Application for removal or variation of a condition following grant of
planning permission. Town and Country Planning Act 1990.
Planning (Listed Buildings and Conservation Areas) Act 1990

Number	
Suffix	
Property name	Moorings
Address line 1	Gorse Avenue
Address line 2	
Address line 3	
Town/city	East Preston
Postcode	BN16 1SQ
Description of site location must be completed if postcode is not known:	
Easting (x)	508673
Northing (y)	101494
Description

Alterations to side hipped roof to new sussex barn half hipped roof and widen existing front dormer windows, alterations to rear roof elevation from hipped to gable end and addition of matching ground floor bay window to rear

K/58/20/HH

Drawing no. **KG/GA/06**

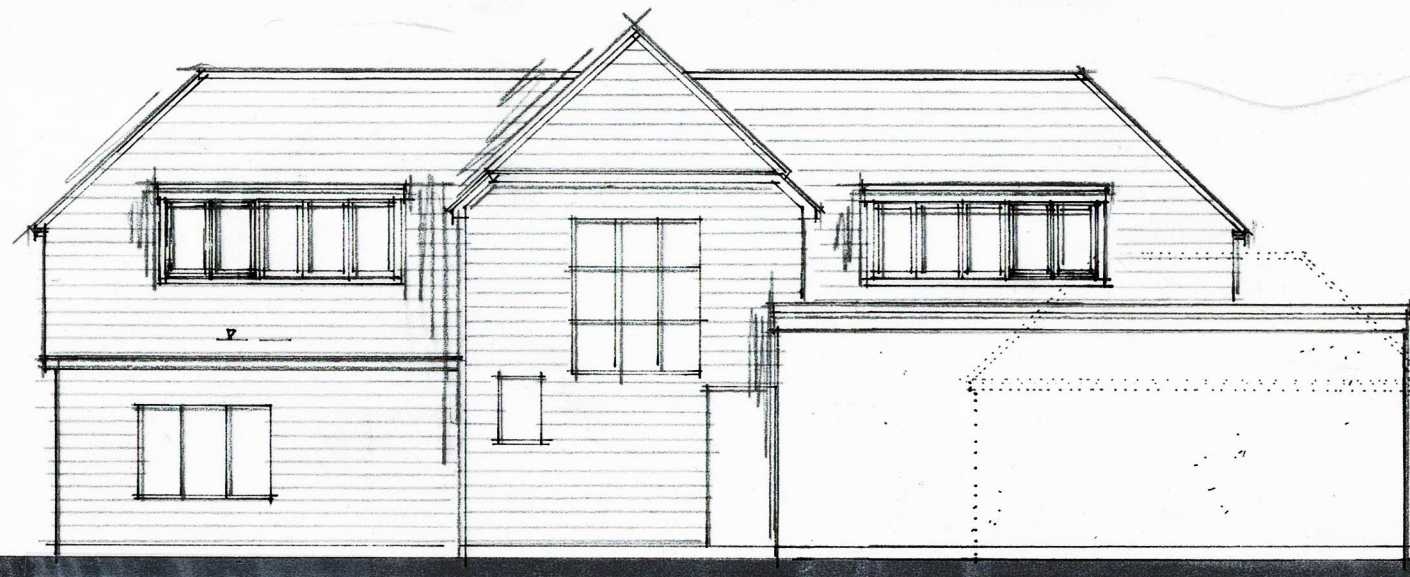
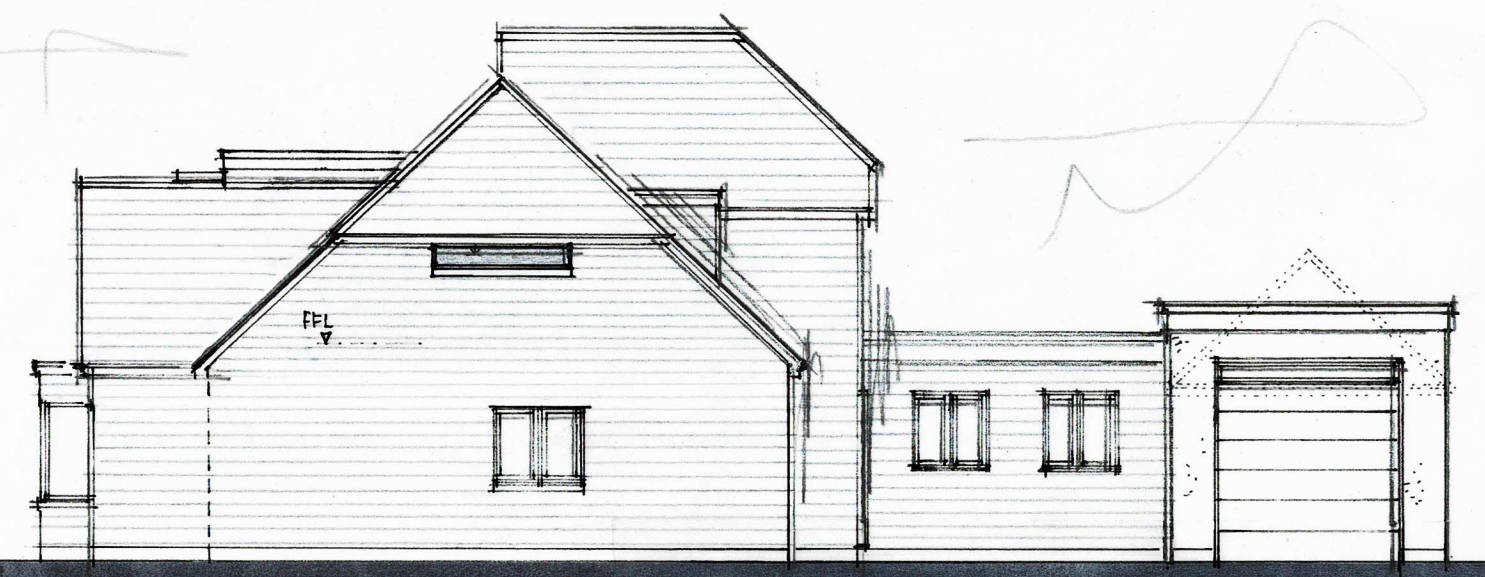
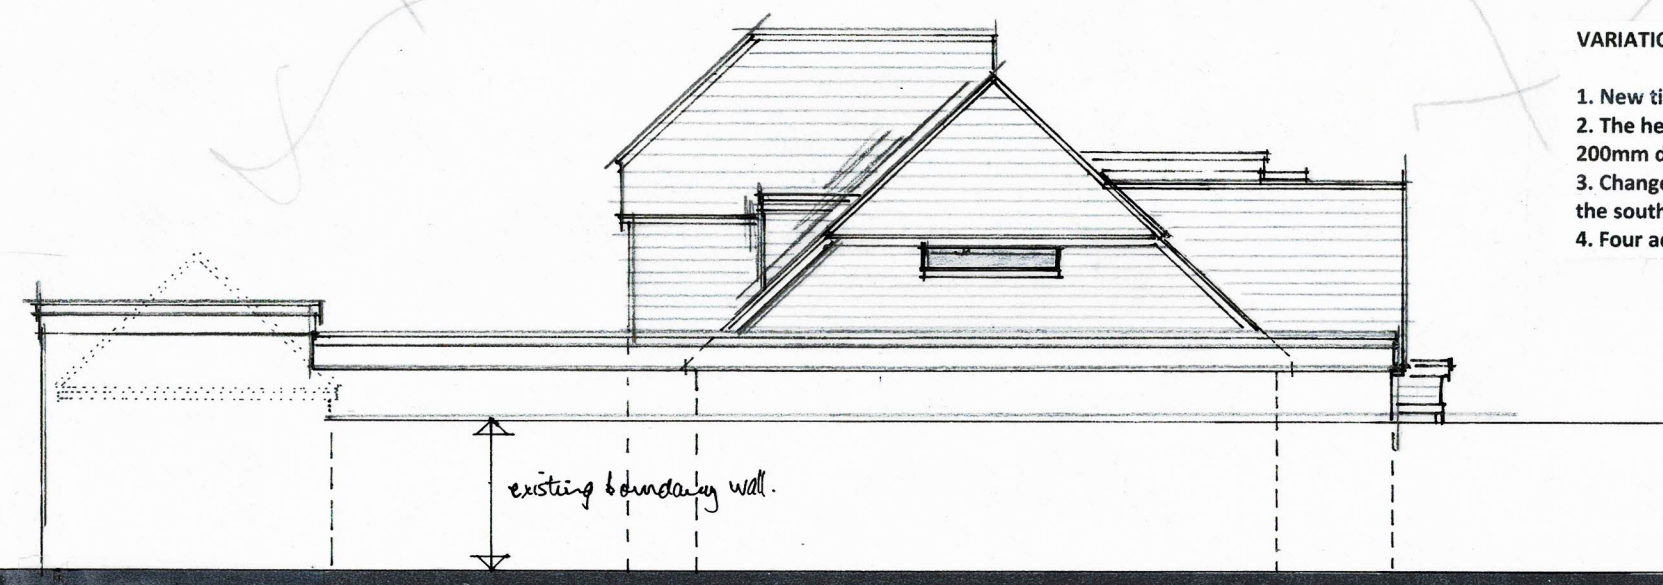
1. New timber shingle tiles to the main roof, dormers and wall elevations.
2. The height of the east and west facing 1st floor windows increased from 200mm deep to 300mm.
3. Change in the fenestration of the glazing panels to both gable apexes on the south elevation
4. Four additional velux style rooflights to the south facing roof slope.
